West Burton Solar Project

Land Plan Revision B – Change Application Version

Prepared by: Dalcour Maclaren
January 2024

PINS reference: EN010132
Document reference: CR1/WB2.2_B
APFP Regulation 5(2)(i)

Land Plans
Sheet 1 of 10
Revision A

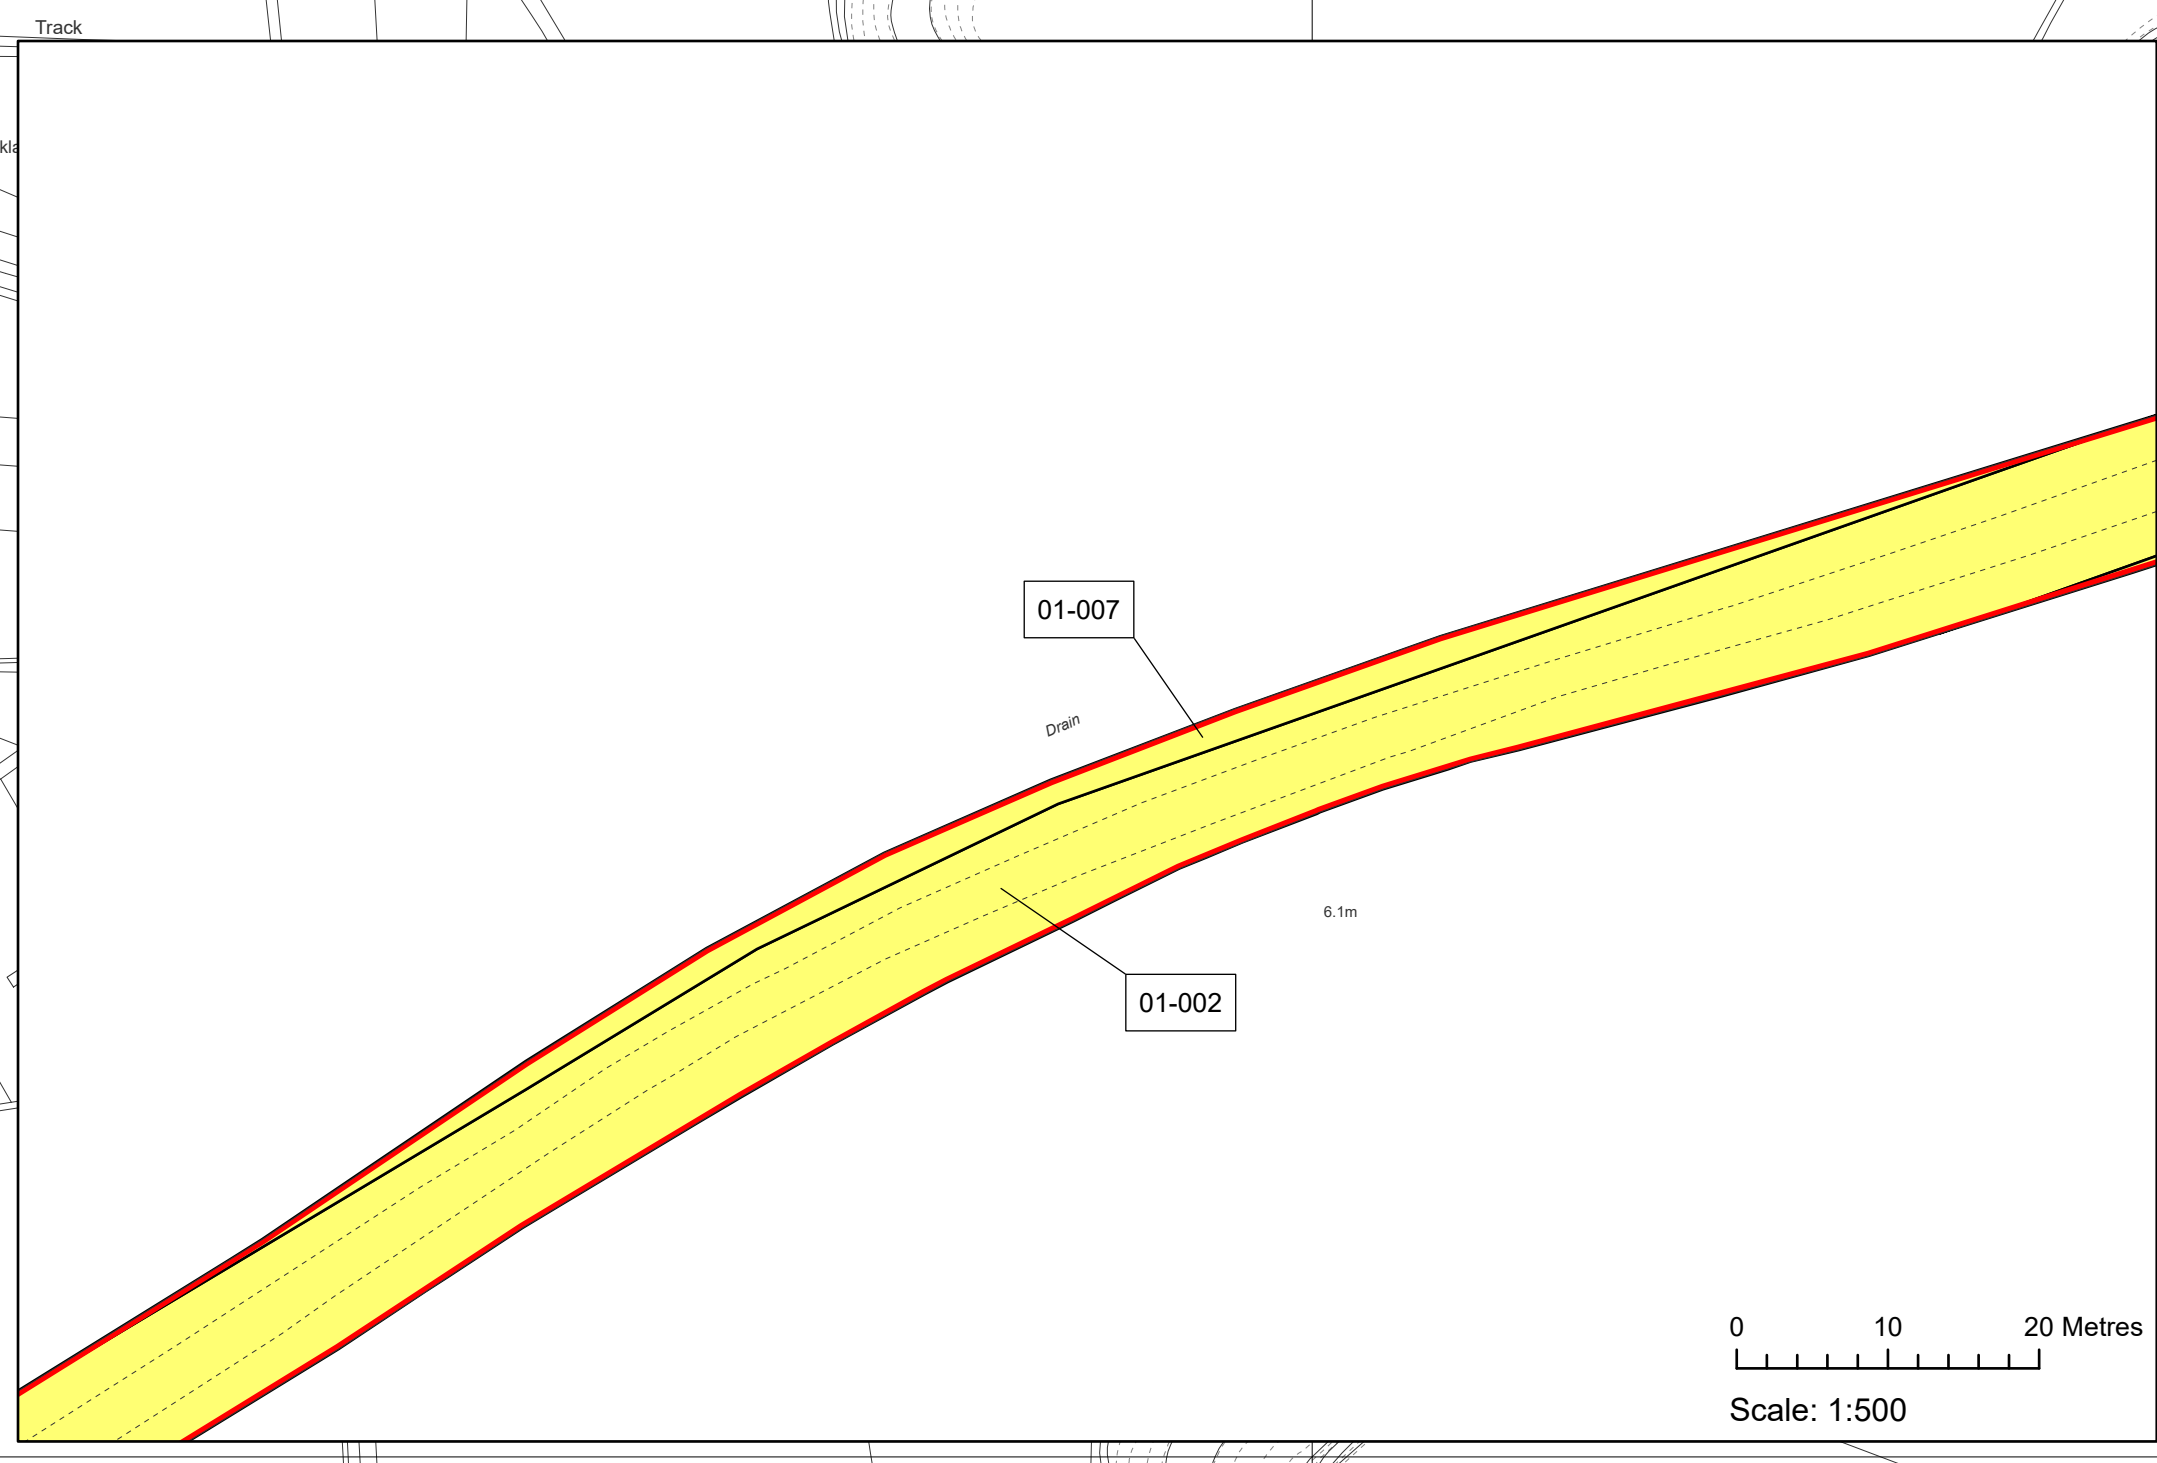
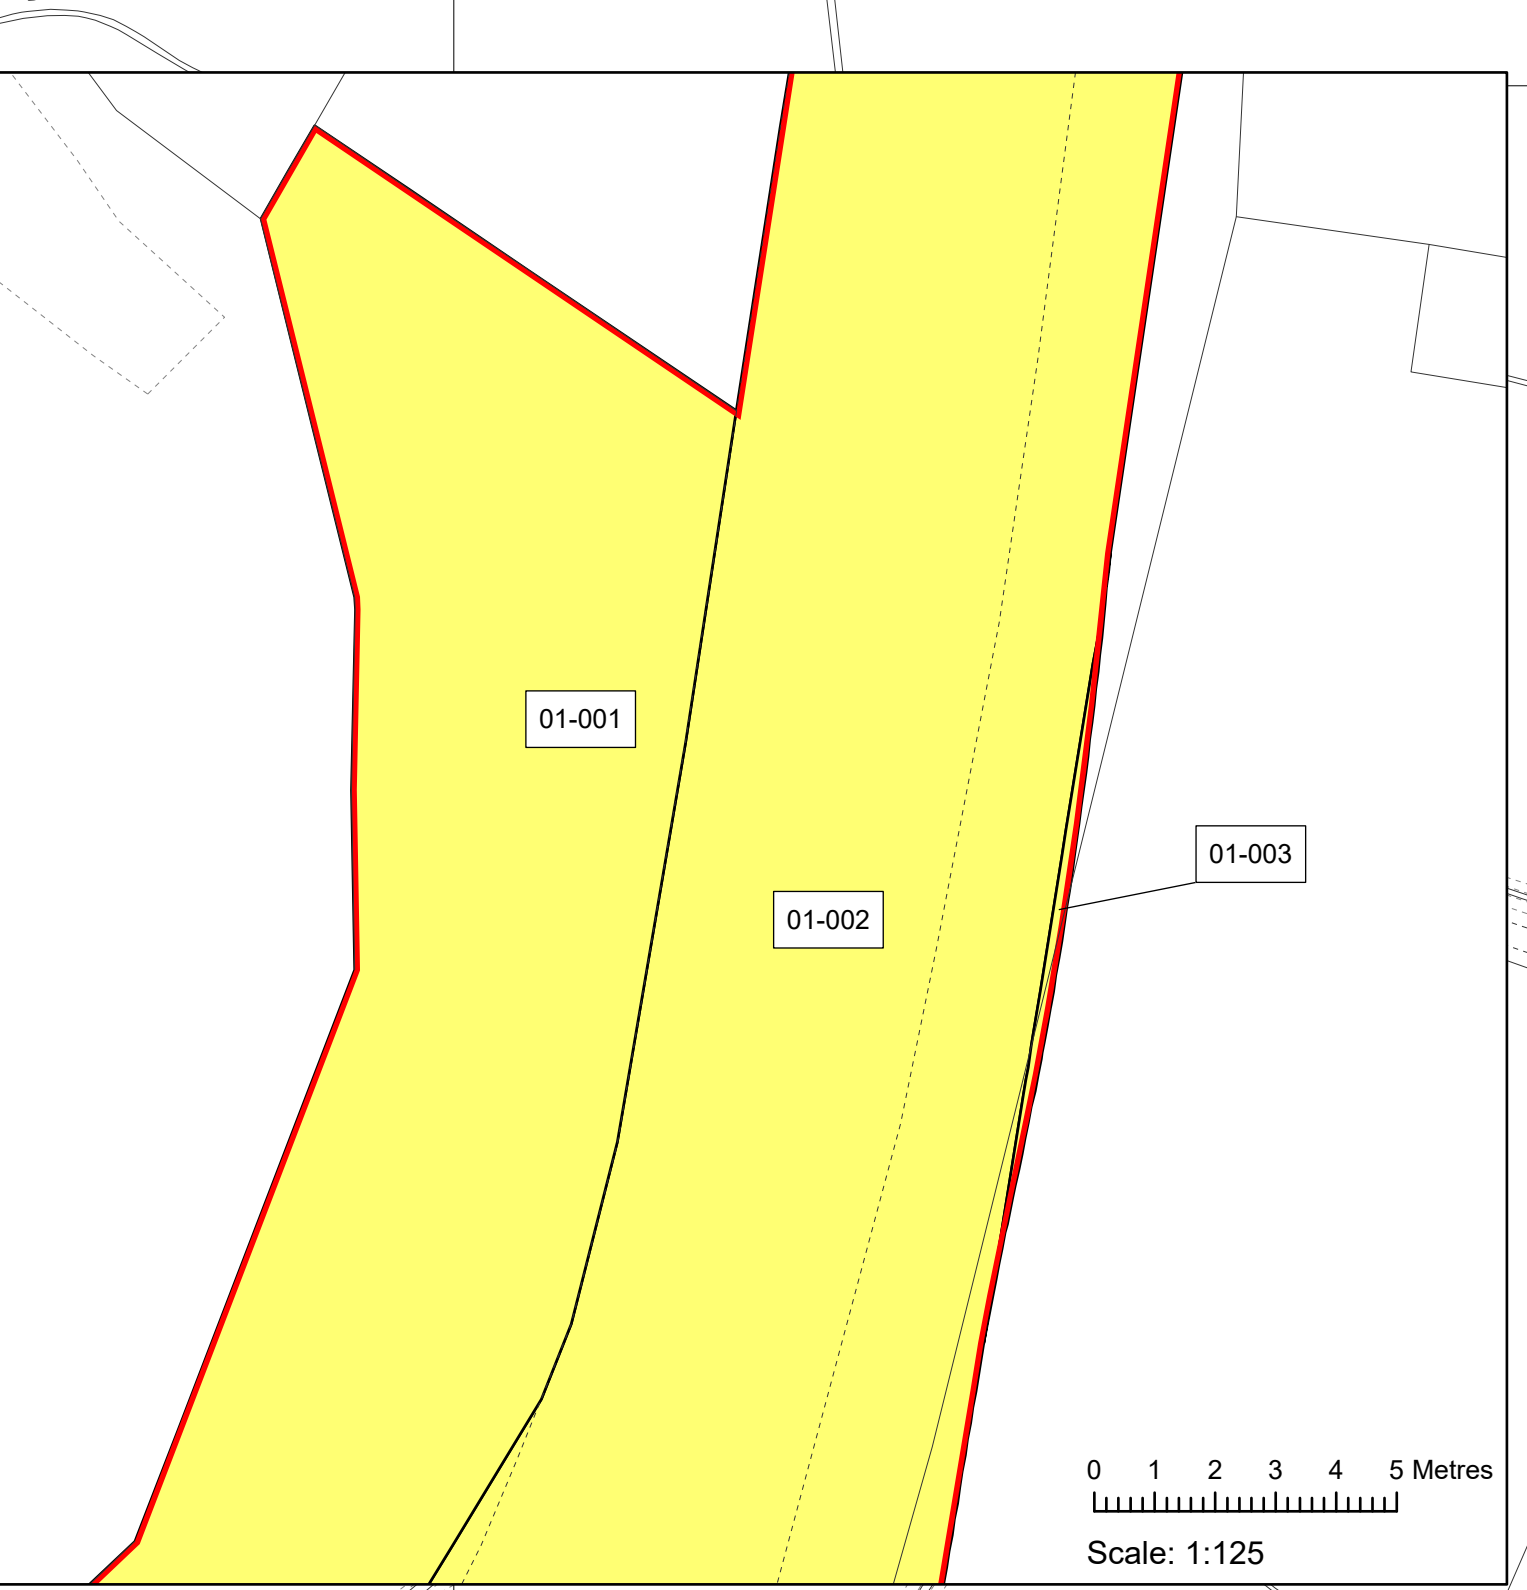
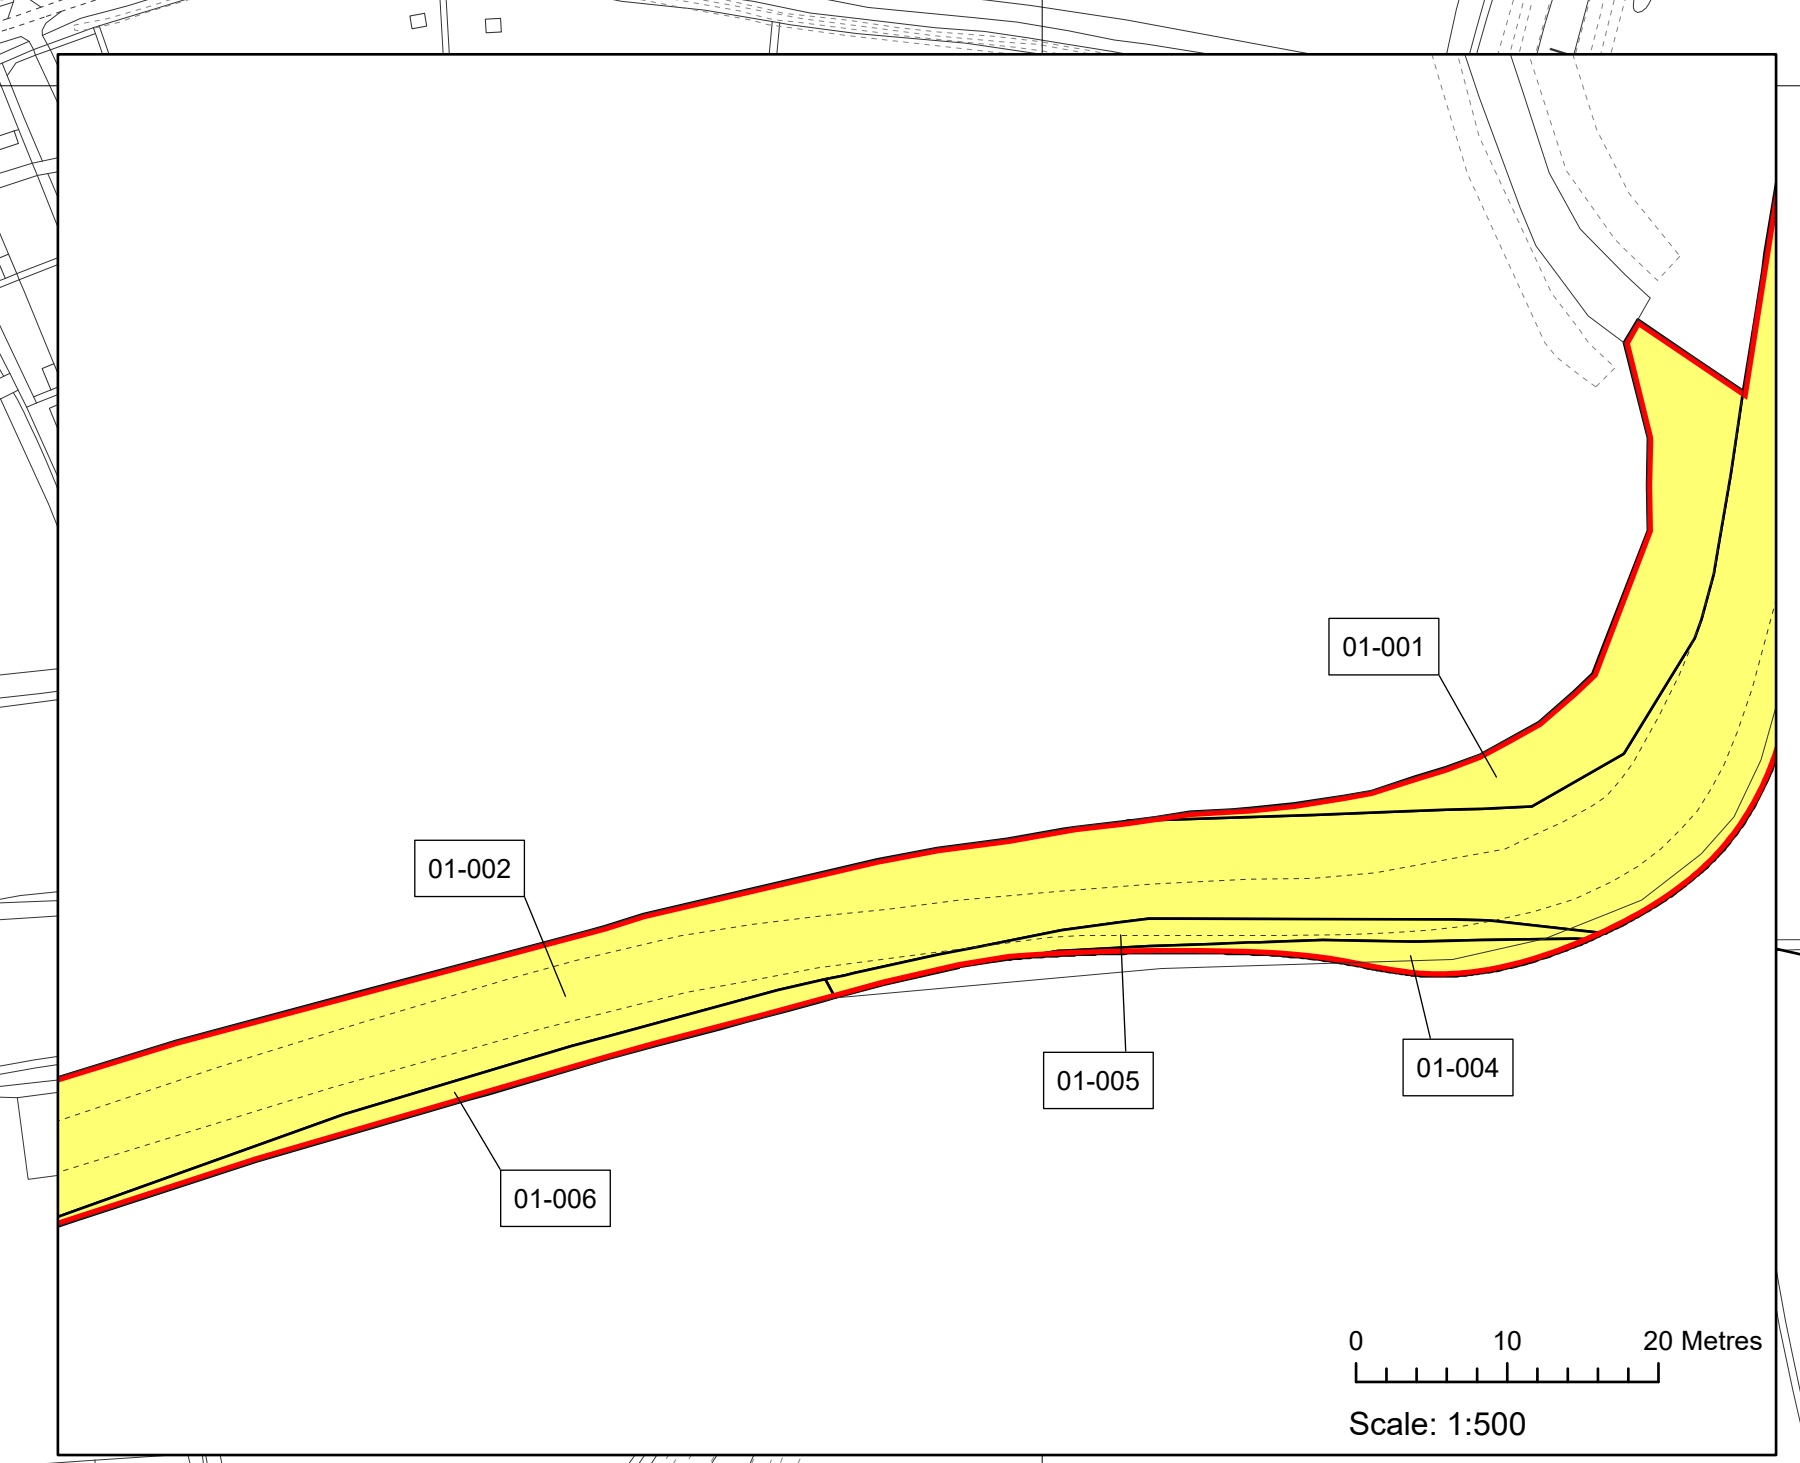
Sheet 1 of 10	5	New plot added	Changes in the Red Line Boundary have created plot 01-002a
Sheet 1 of 10	5	Update to the list of plots in the key on Sheet 1	Updated to reflect addition of new plot 01-002a

Land Plans
 Sheet 5 of 10
 Revision A

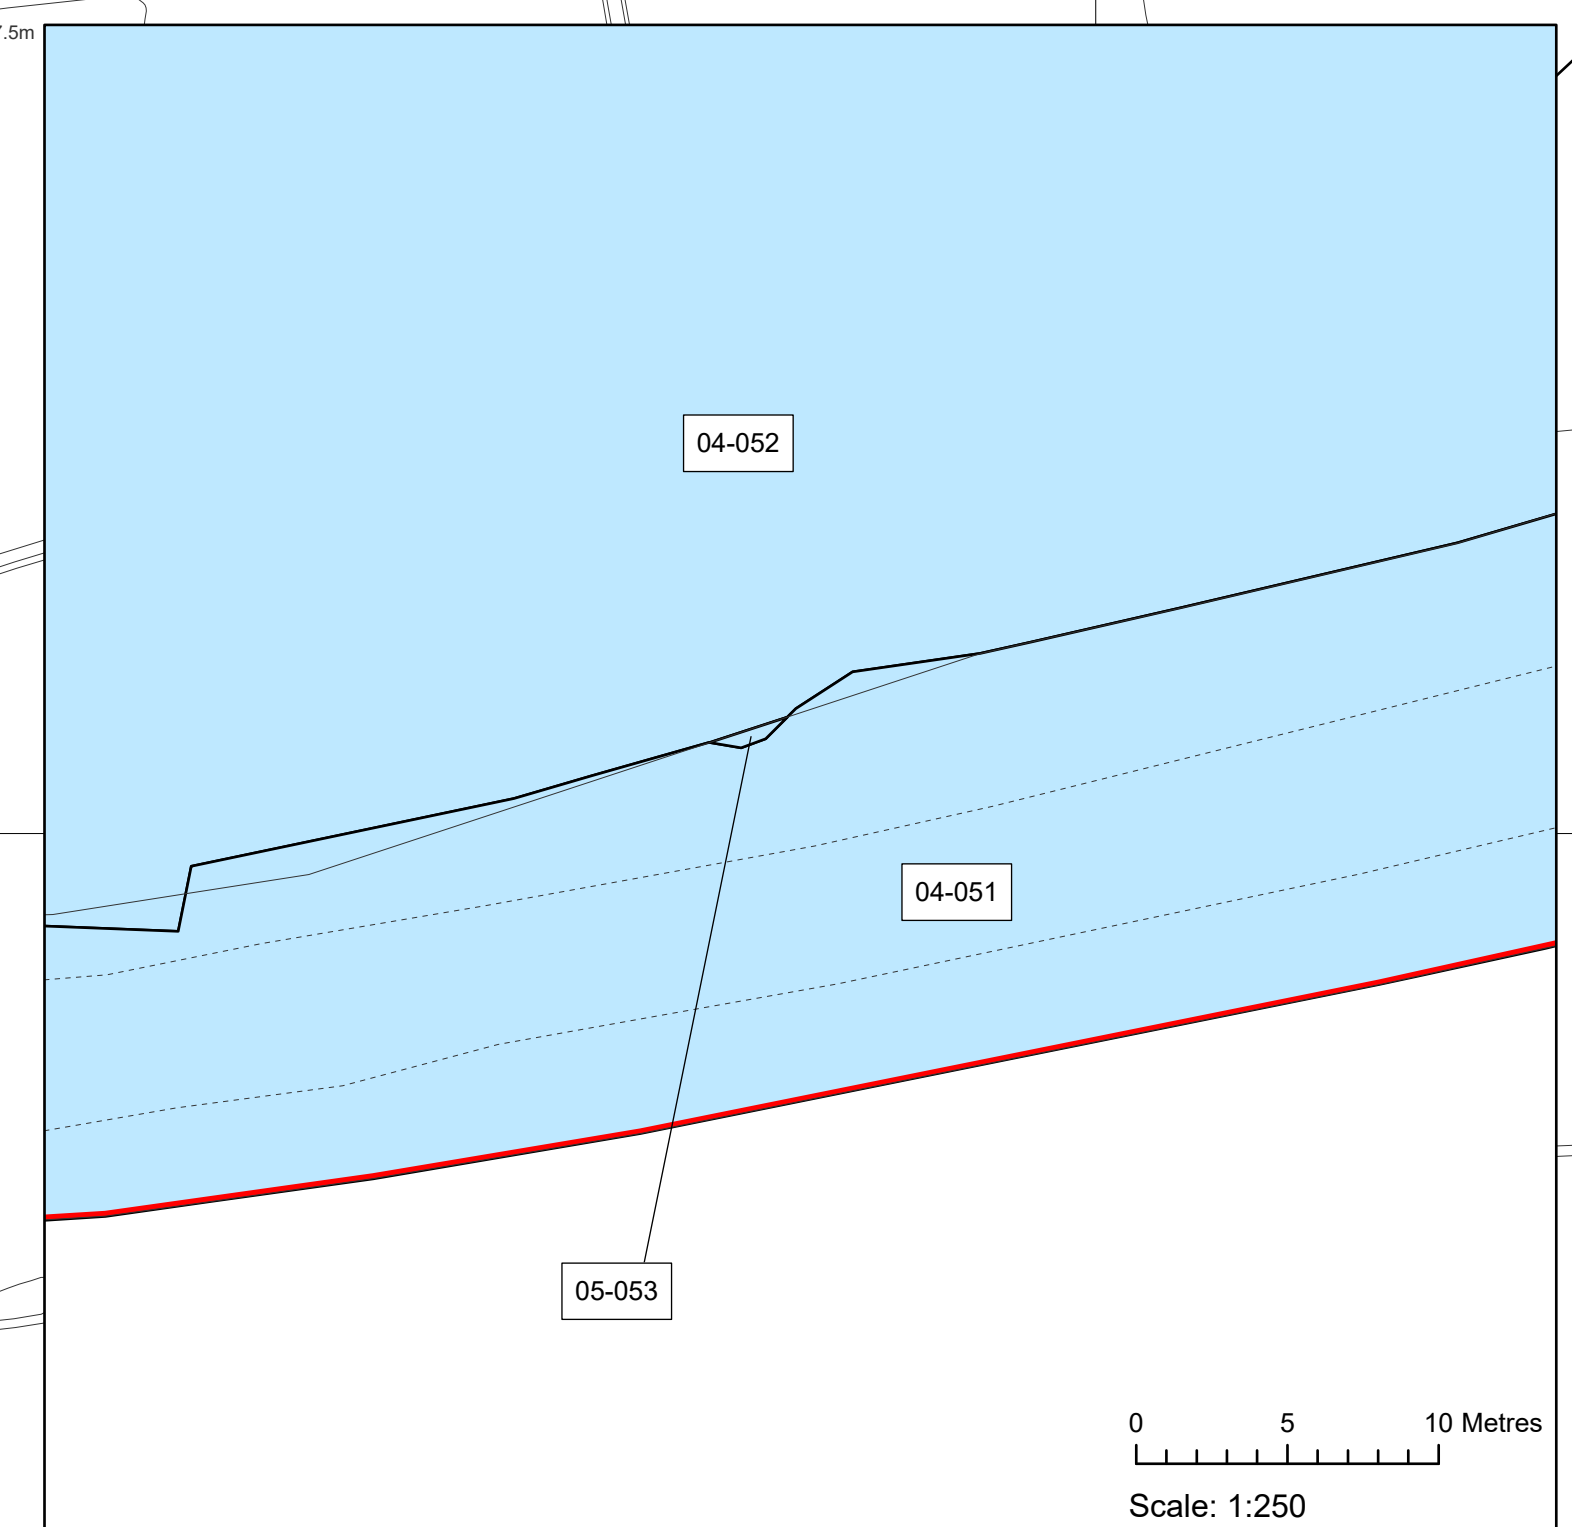
Sheet 5 of 10	9	New plots added	Changes in the Red Line Boundary have created plots 05-052a & 05-054a
Sheet 5 of 10	9	Plot acquisition type changes	Changes to acquisition required for sufficient flexibility for plot 05-054

Sheet 5 of 10	9	Update to the list of plots in the key on Sheet 5	Updated to reflect addition of new plots 05-052a & 05-054a. Updated to reflect change in acquisition of 05-054a
